WRITTEN REPRESENTATION ON BEHALF OF NORFOLK WILDLIFE TRUST

Application by East Pye Solar Limited for the East Pye Solar Development Consent Order

Planning Inspectorate Reference: EN0110014

**Figure 8.4 - Irreplaceable Habitats within 2km**  
 Sheet 2 of 6  
 Revision A

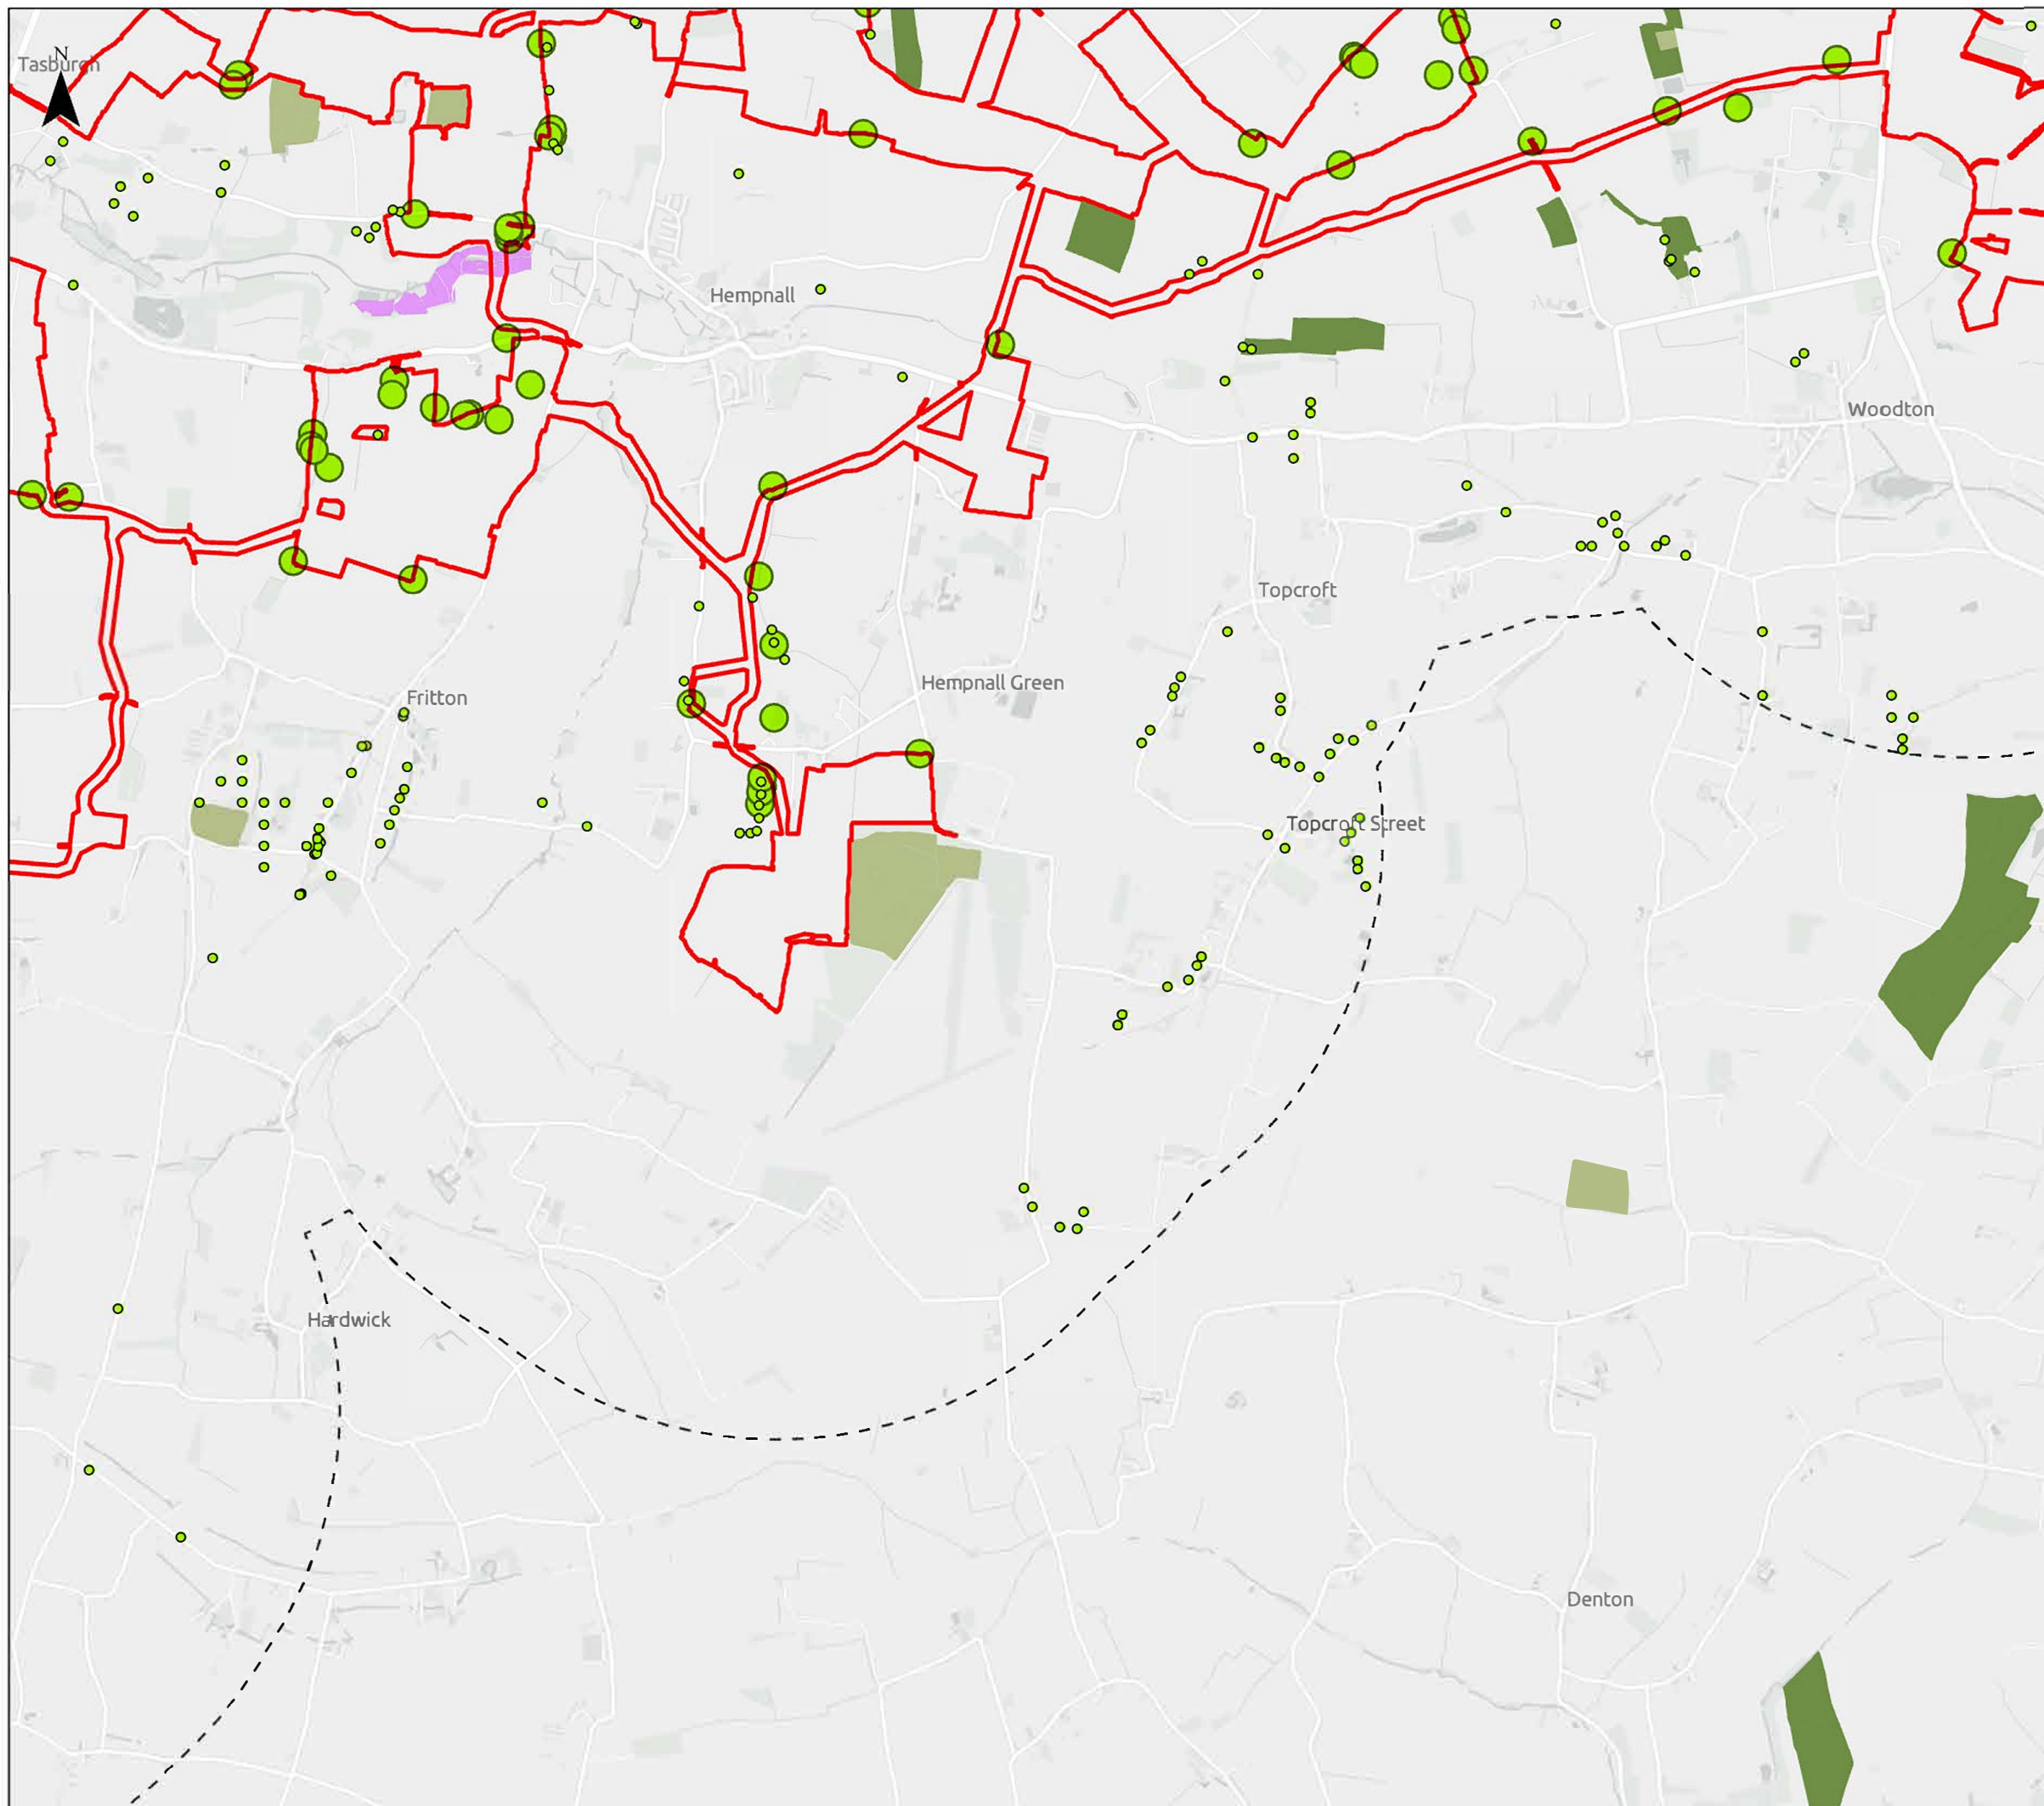
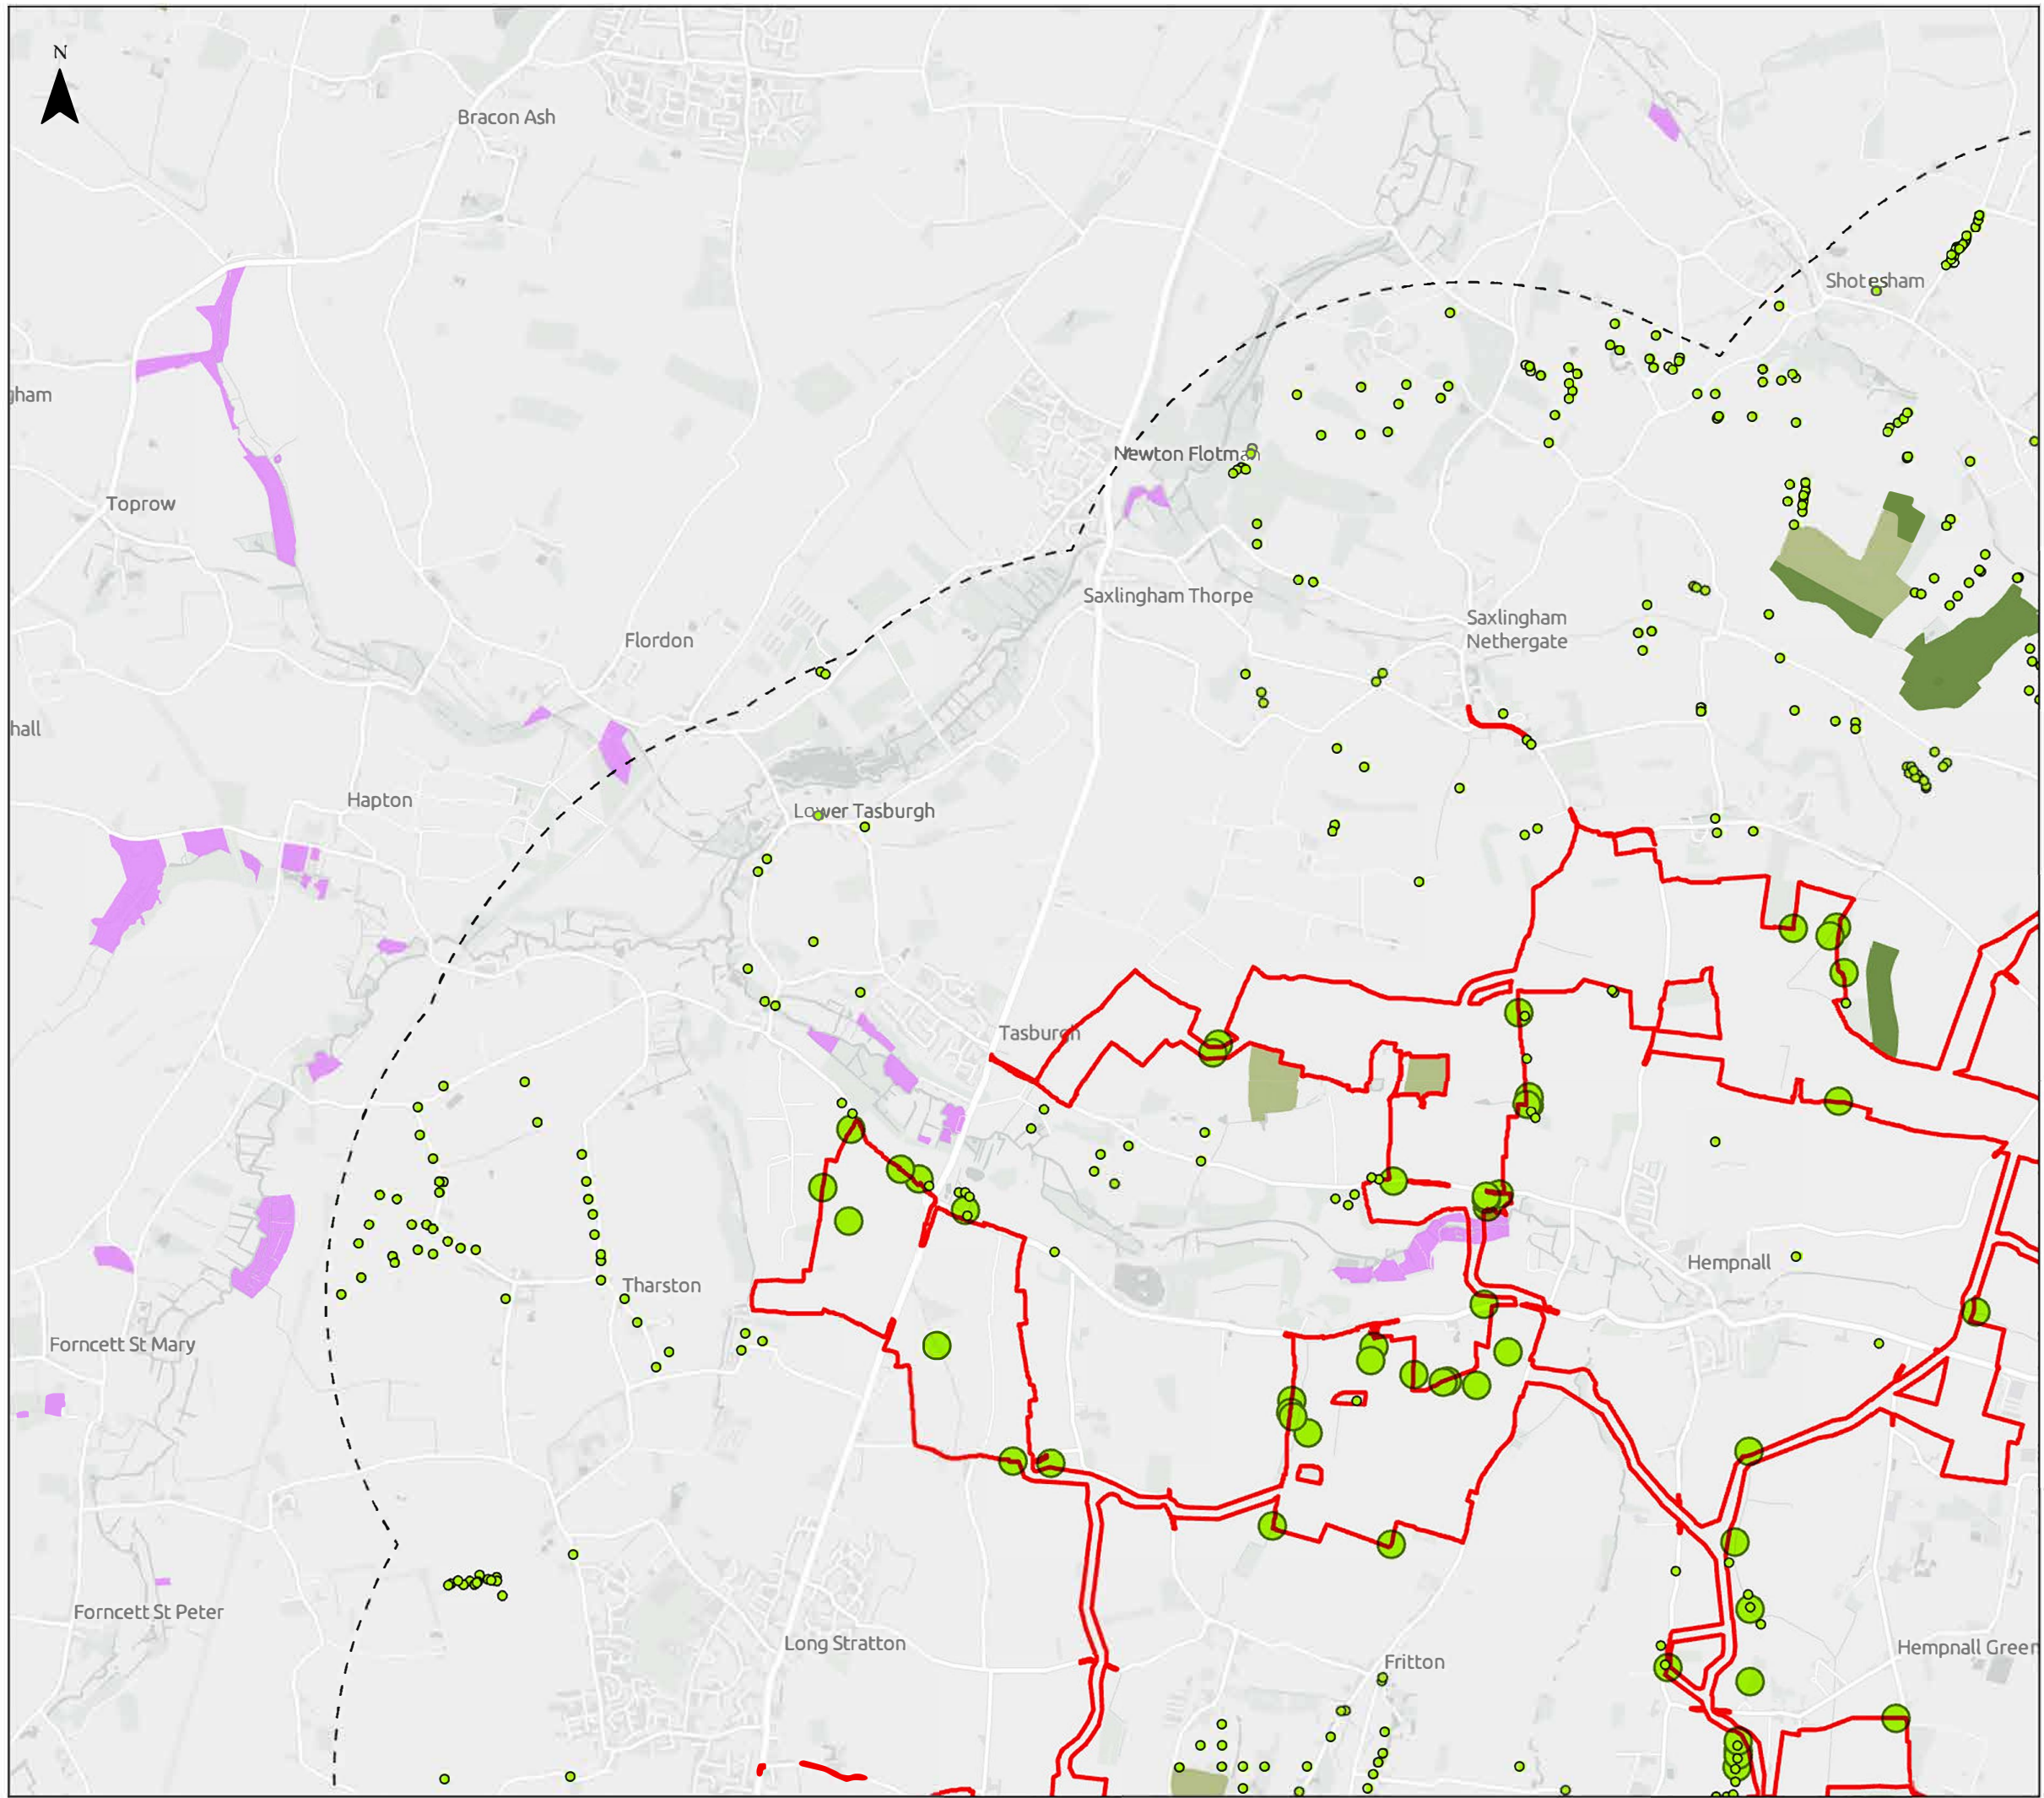
- This includes an area of lowland fen habitat within the cable route corridor. Lowland fen is an irreplaceable habitat and is highly sensitive to hydrological change, groundwater disturbance, compaction and pollution. It is stated that Horizontal Directional Drilling (HDD) will be used and the Outline CEMP includes design measures to reduce impacts through run-off control, pollution prevention and dust control during construction and specifies Stand-off distances of 30m from the CWS, which we welcome.

- However, section 4.4 of the Outline Cable Route Construction Statement states that the technology used for the HDD will be determined by feasibility studies carried out at each crossing during the detailed design stage and in accordance with a method statement. The Outline CEMP also states that a Hydrogeological Risk Assessment will be undertaken, "if required". Although the applicant states that HDD will pass beneath the fen at a depth of at least 5m, insufficient evidence has been provided to demonstrate that construction activities will not affect groundwater conditions or the hydrological processes upon which the fen depends. The applicant has also stated that a Water Management Plan will form part of a detailed CEMP and will include details of pre-construction, construction, and post-construction water quality monitoring. Further details are required to allow proper scrutiny.

- The oCEMP confirms that the precise locations of HDD entry and exit points will only be determined at the detailed design stage. Without this information it is not possible to fully assess the ecological impacts or determine whether the proposed buffer distances are sufficient. HDD entry and exit locations should be identified prior to examination close.
